CITY OF ALBUQUERQUE

December 27, 2017

**Re: Floor and Decor
Erosion and Sediment Control Plan
Engineer's Stamp Date 10-17-17 (F17E032)**

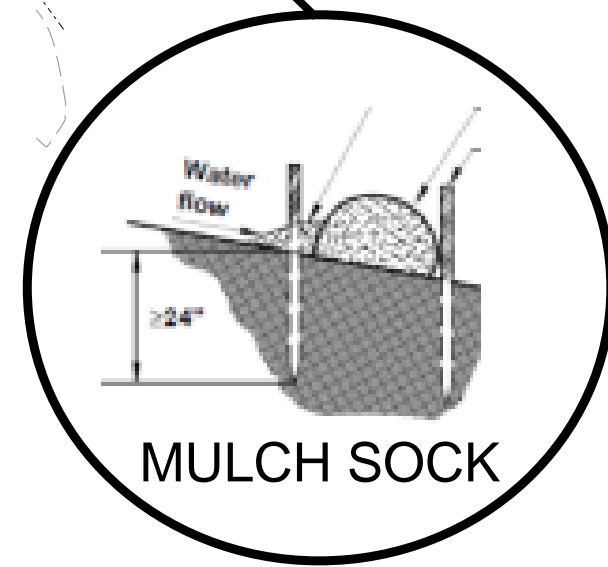
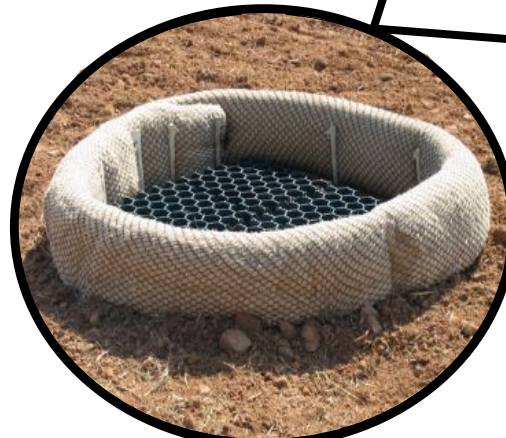
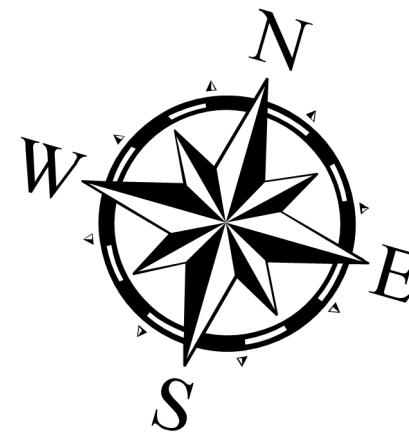
1. It appears that grading is proposed to the back of curb on McLeod Rd. If this is the case, the silt fence will need to be installed at the back of curb.
